Ribble Valley Borough Council
Housing & Development Control

Application no: **3/2023/0150**

Address: **78 Hacking Drive Longridge PR3 3FP**

Proposal: **Proposed two storey side extension, single storey rear extension and enlargement of front and rear dormers.**

Proposed Site Plan (1:100)

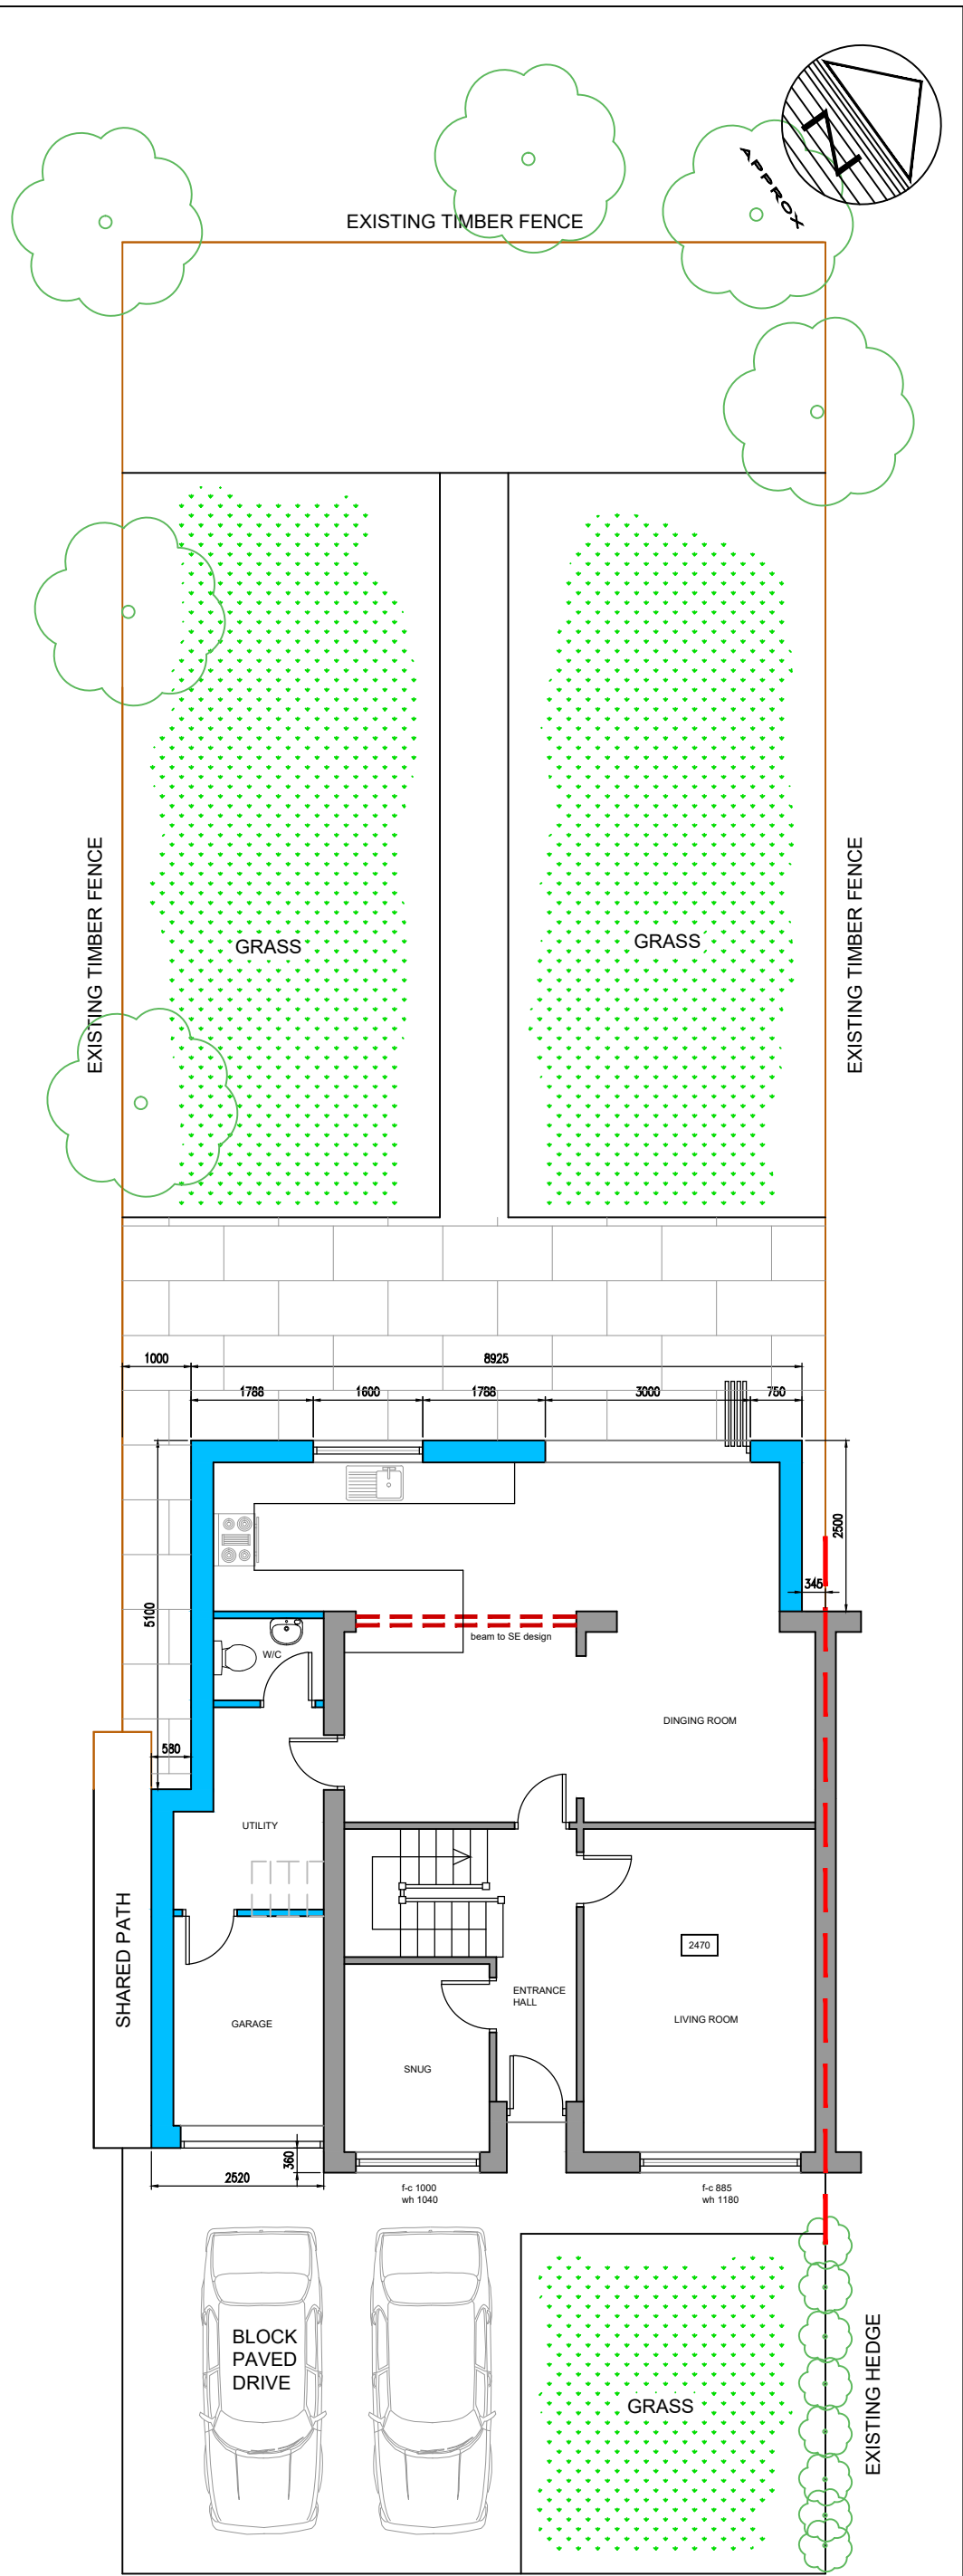
The LHA have reviewed drawing number DR-002 Rev A titled "Proposed Floor, Roof, Site Plans and Elevations" and are aware that access will be extended to 6.7m wide to allow for 3 car parking spaces to be provided on the existing driveway for the proposed 4 bed dwelling. This complies with the LHAs parking guidance as defined in the Joint Lancashire Structure Plan.

The LHA would prefer that the access is extended to 7.2m wide but will accept the shortfall given that the proposed driveway is a minimum of 7.2m wide, at a distance of 0.8m from the adopted highway, for the full duration of its depth. Therefore, 3 vehicles are able to park on the driveway and so the LHA have no objection to the proposal.

1.No part of the development hereby permitted shall be occupied until such time as the access arrangements shown on drawing number DR-002 Rev A have been implemented in full.

3.The development hereby permitted shall not be occupied until such time as the parking and turning facilities have been implemented in accordance with drawing number DR-002 Rev A. Thereafter the onsite parking provision shall be so maintained in perpetuity.
